**Re: Kendall Subaru – PA22-035 – Technical Review 1**  
16xxx Smokey Point Blvd – APN(s): 31052800300600 / 31052800300300 / 31052800301200

After review of the preliminary Site Plan Review, the Planning Division has the following comments:

RE: Kendall Subaru Auto Dealership, File#PA22-035  
Review for the construction of a 69,258 sq. ft. auto dealership and SEPA review.  
16xxx Smokey Point Blvd & Parcel #'s 31052800300600, 31052800300300,  
31052800301200

Marysville Municipal Code: 22C.020.250(4)(d) Commercial Ext. Lighting / 22C.130.50(3)(d) Parking Illumination

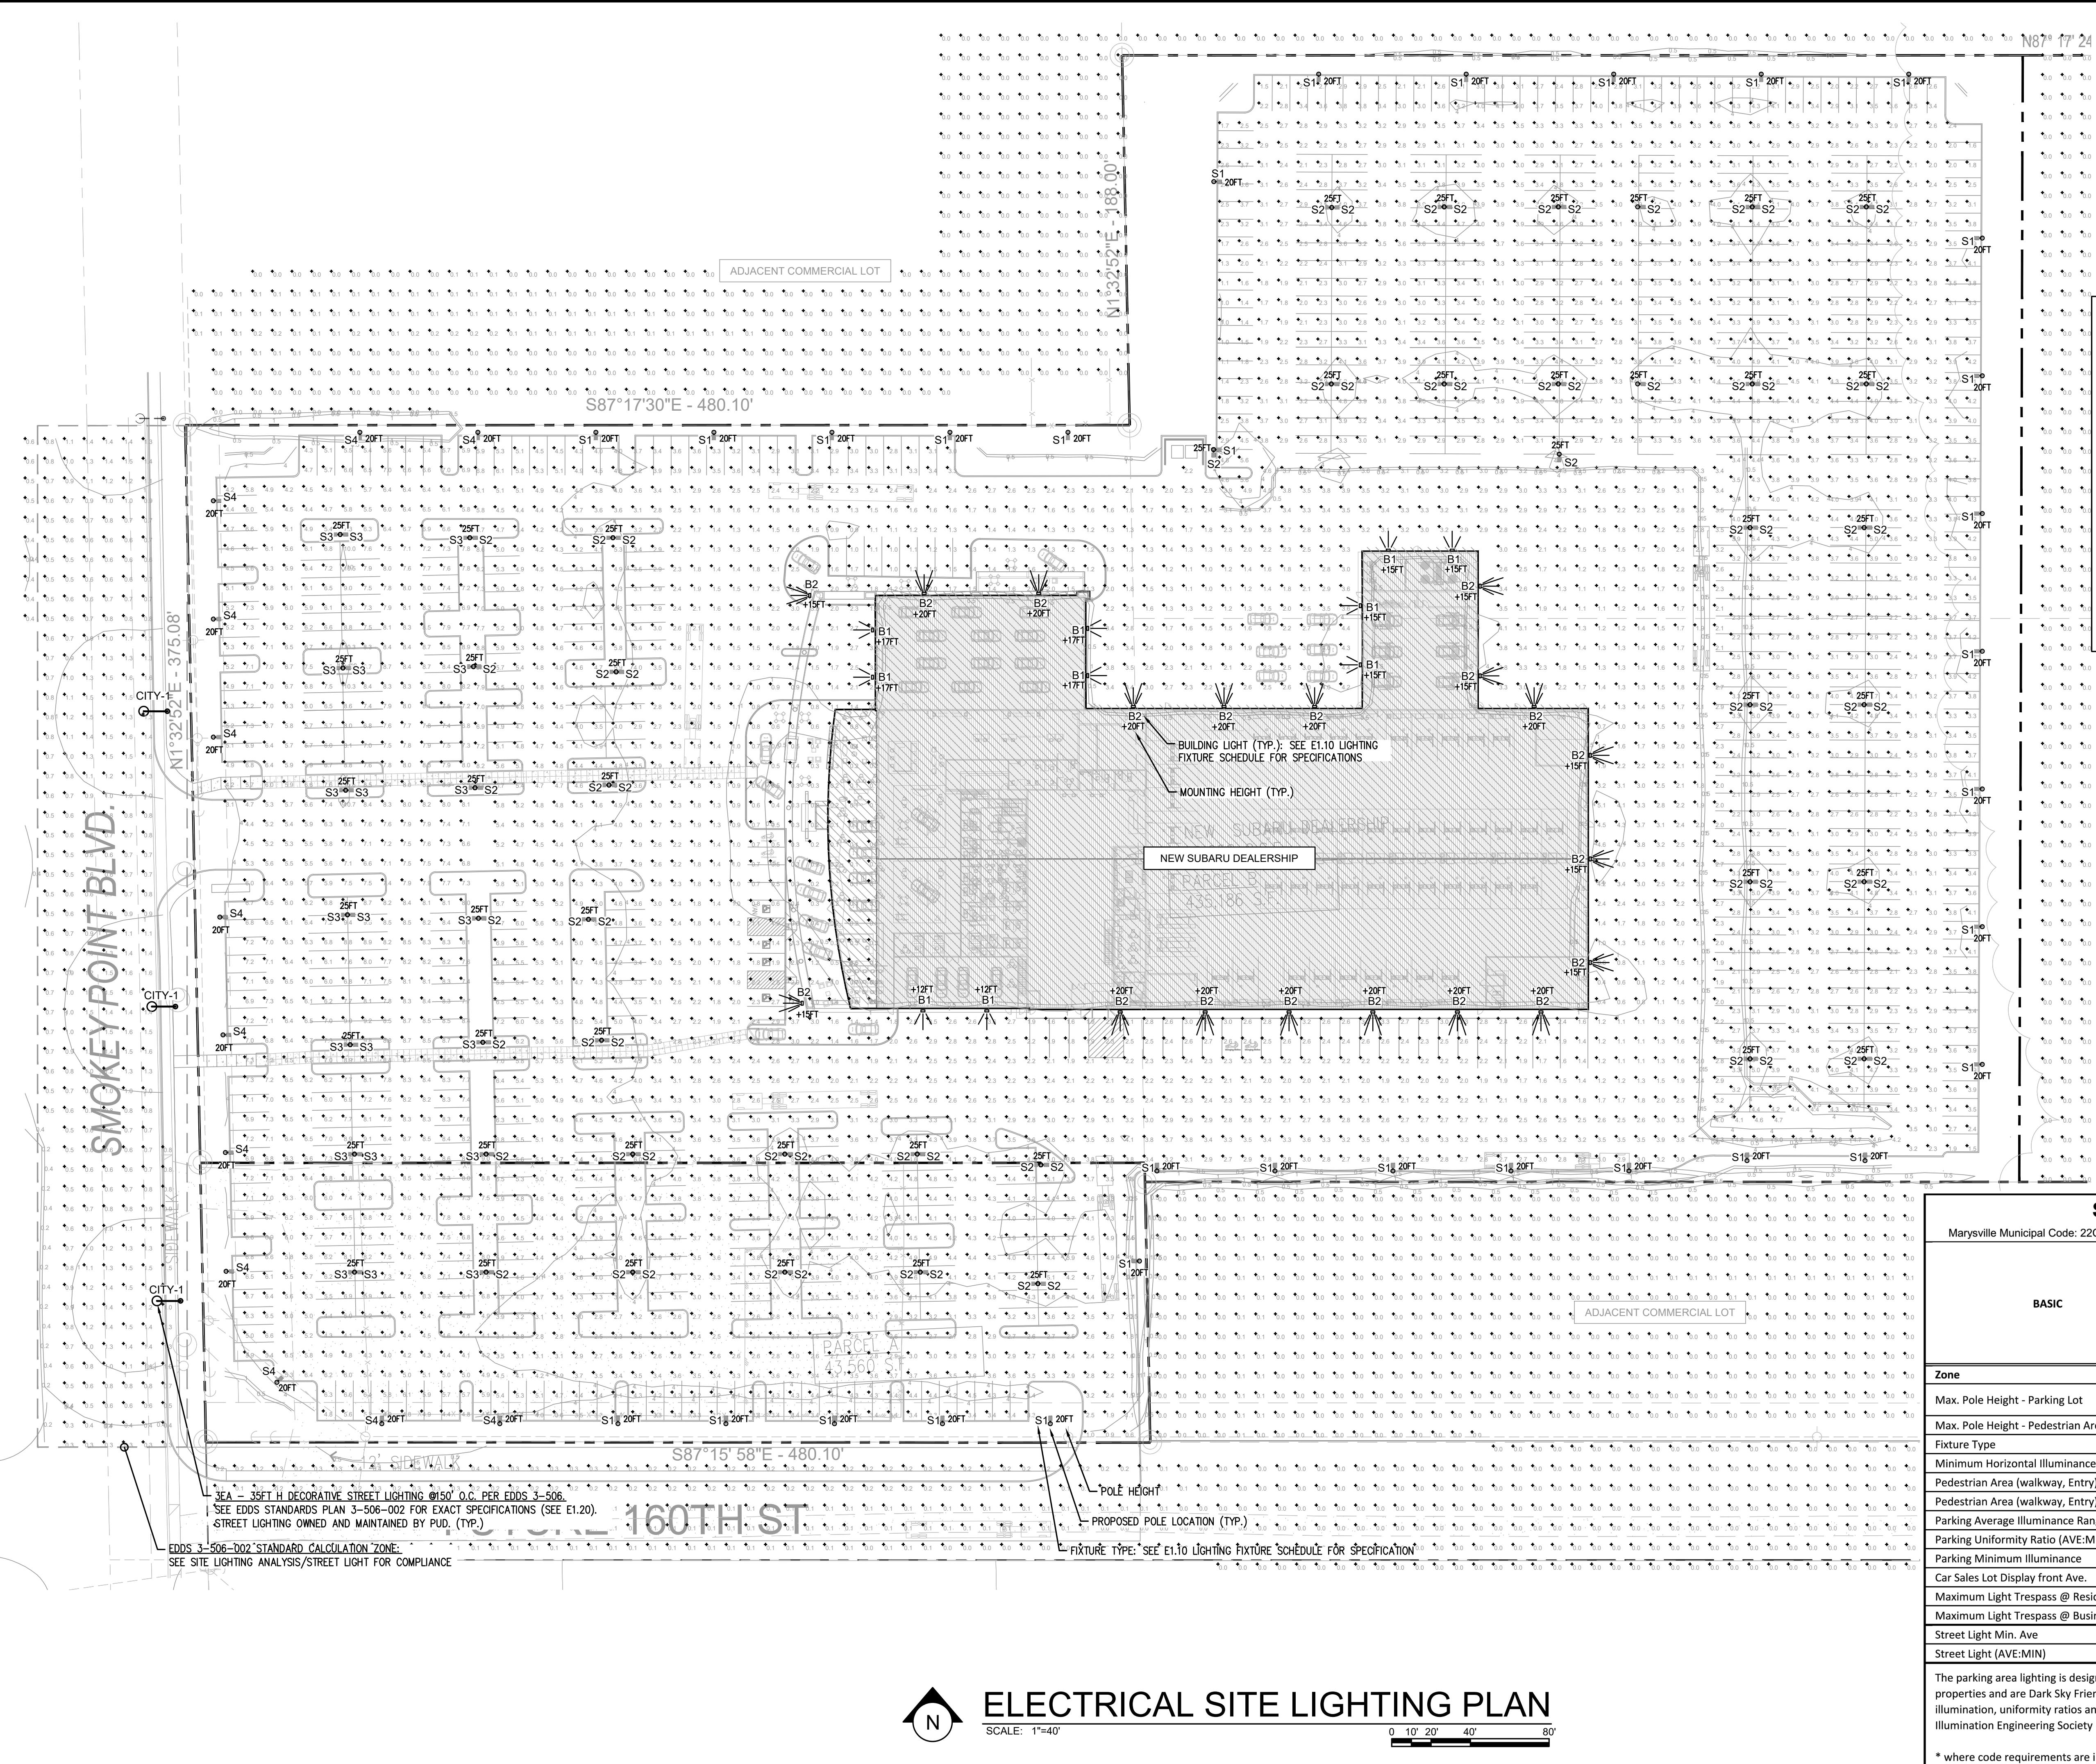
5. Based on the lighting plans, the proposed pole lights within the parking areas are to be 25 ft. in height. Confirm that all proposed fixtures would meet the required standards of MMC 22C.130.050(3)(d).

**1** 80' RIGHT-OF-WAY ROAD SECTION  
**C5.0** SMOKEY POINT BLVD.  
NO SCALE ROAD CLASSIFICATION: ARTERIAL  
DESIGN SPEED: 30 M.P.H.

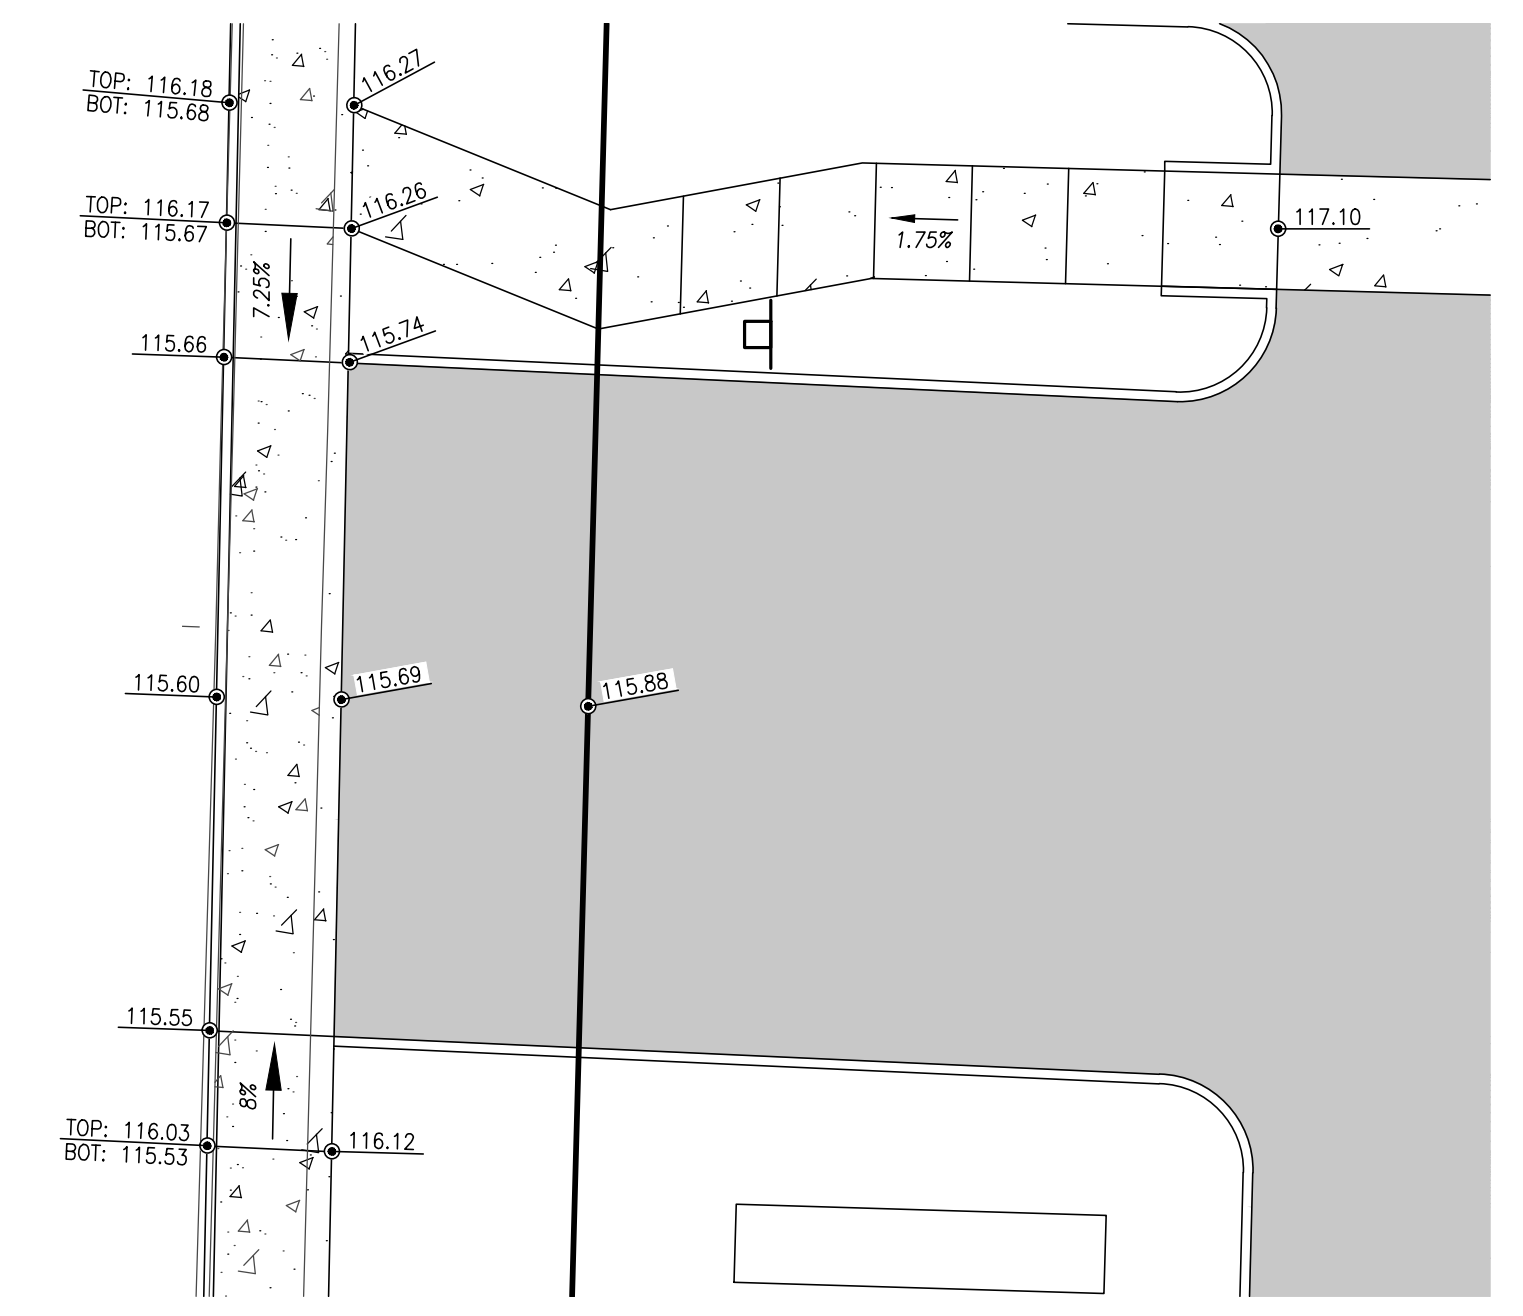
- a. The sidewalk along Smokey Point Blvd. is adjacent to the curb, as such it is to be a 6 foot wide sidewalk. The sidewalk shall be removed and replaced with a 6 foot sidewalk.
- b. 160<sup>th</sup> Street is to be a 3 lane arterial with planter strips and a 12 foot multiuse path. The project is required to construct a half street for asphalt, which is 20 feet in width and the curb and gutter, a 5 foot planter strip and the multiuse path.
